Response at Deadline 5 from Rosemary Lewis. IP 20054900

I have two ongoing concerns. These are the Applicant's continued failure to:

1. Amend the inconsistencies in the Glint and Glare Assessment of the impact on Residential Properties.
2. Carry out an RVAA. This refusal is based on their flawed LVIA which concludes that the need for an RVAA has not been triggered.

Illustrative Masterplan
Figure 2.2D
 Central Site Area 4 of 6

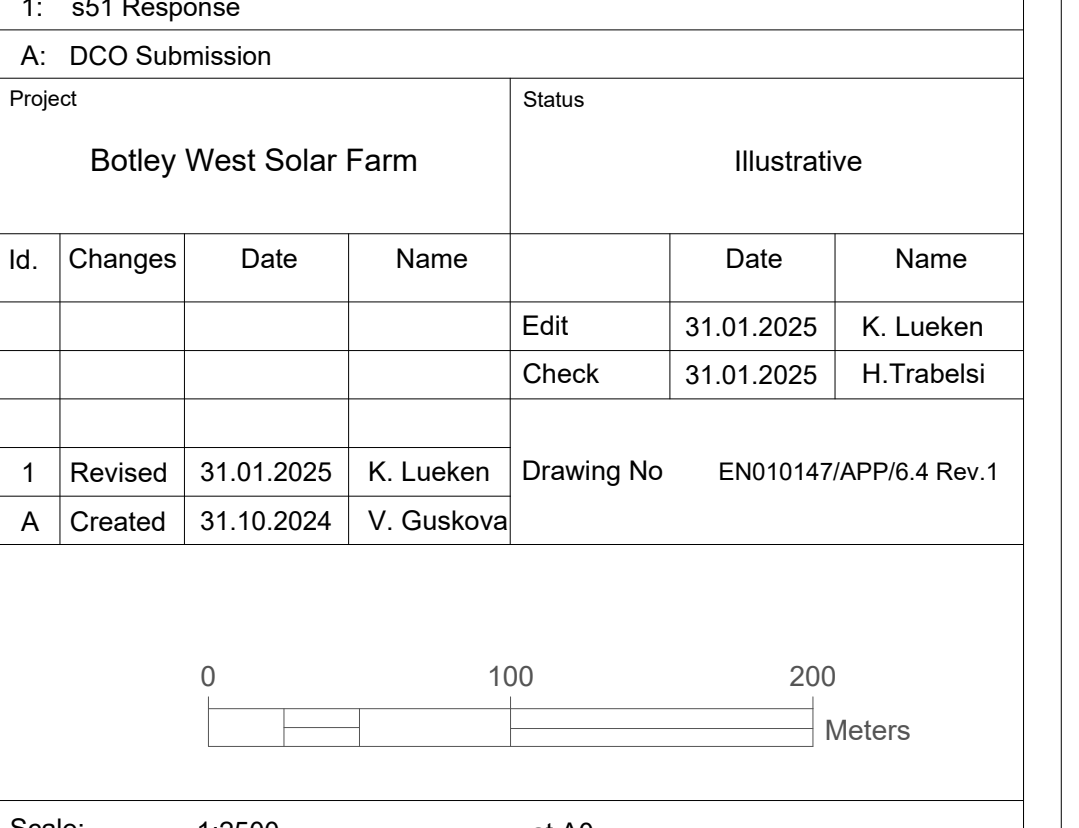
2.7.2.“Additional mitigation, as shown on the Illustrative Masterplan [APP-062]”. The scale of these plans is far too small to identify individual hedge planting.
